Our ref: Aussie Skips Recycling - Bellfrog St Site upgrades (SSD-67497708)

Subject: Request for response to the Department's issues

Attachment 1

Figure 5 - Fire Attack Plan

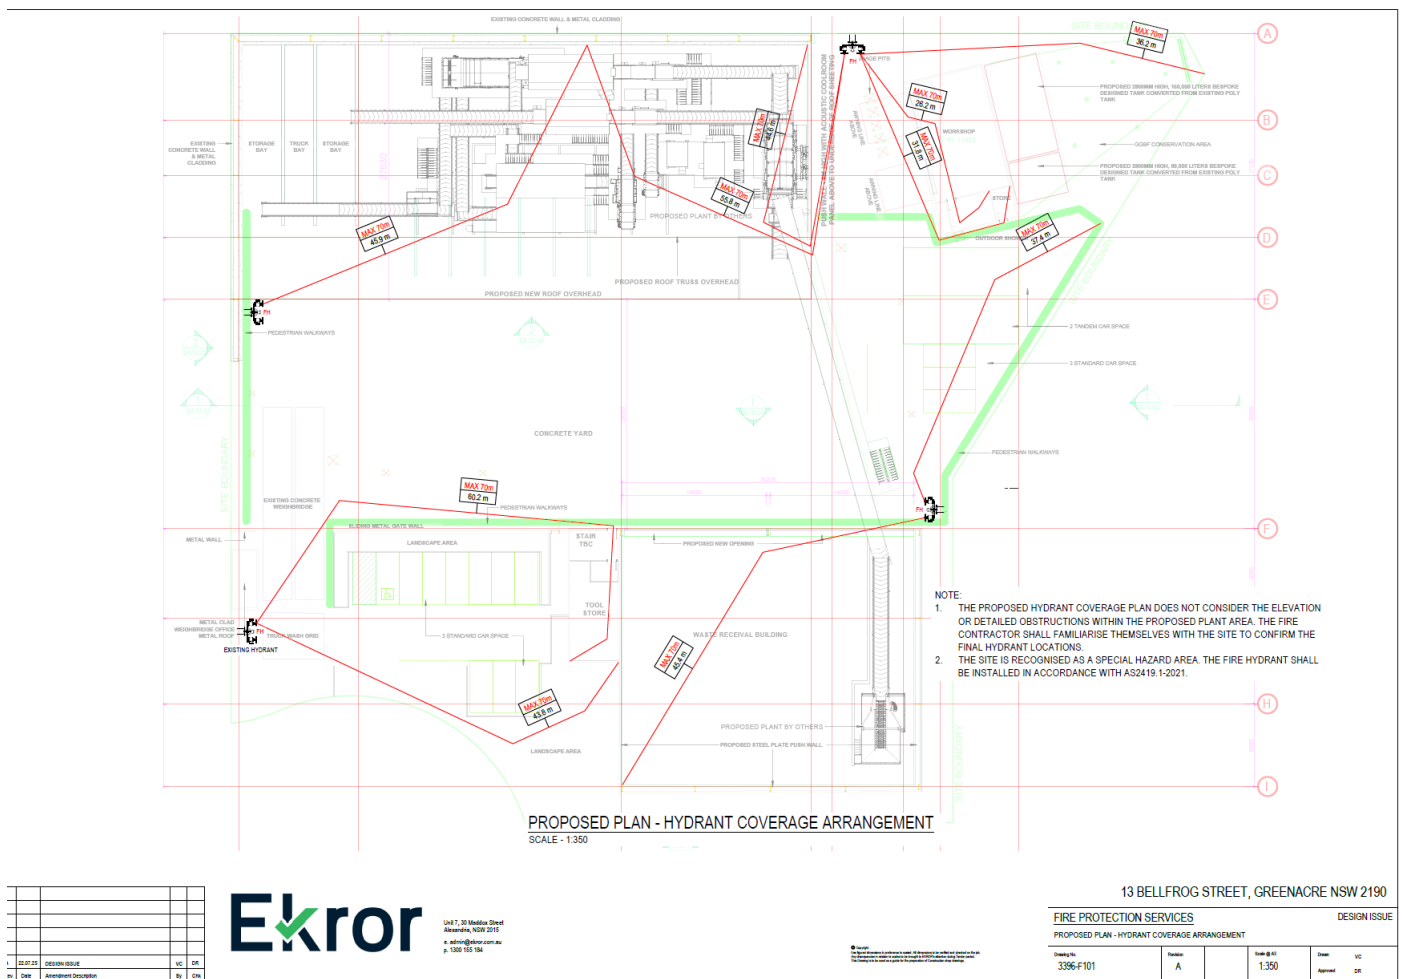
- It is noted FRNSW stated that Perimeter Vehicle Access must be provided. Please include consideration of how satisfactory access for fire vehicles and personnel would be provided.

FIGURE 5: INTERNAL ANTICLOCKWISE CIRCULATION

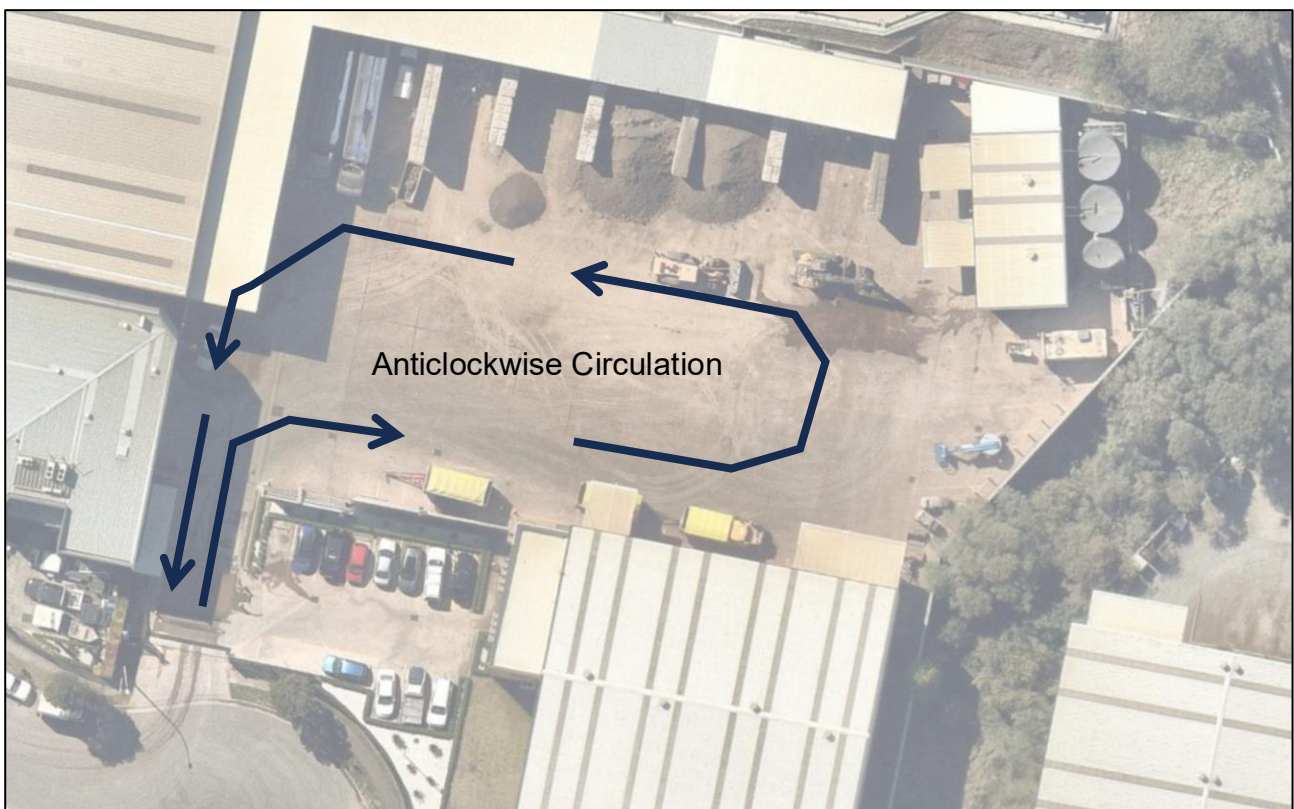
- It is noted dwell times are averaged; dwell times and queueing requirements must be assessed as a worst case. Please provide an updated queueing assessment based on the worst case scenario.
- Describe how internal traffic will be managed to avoid conflicts.
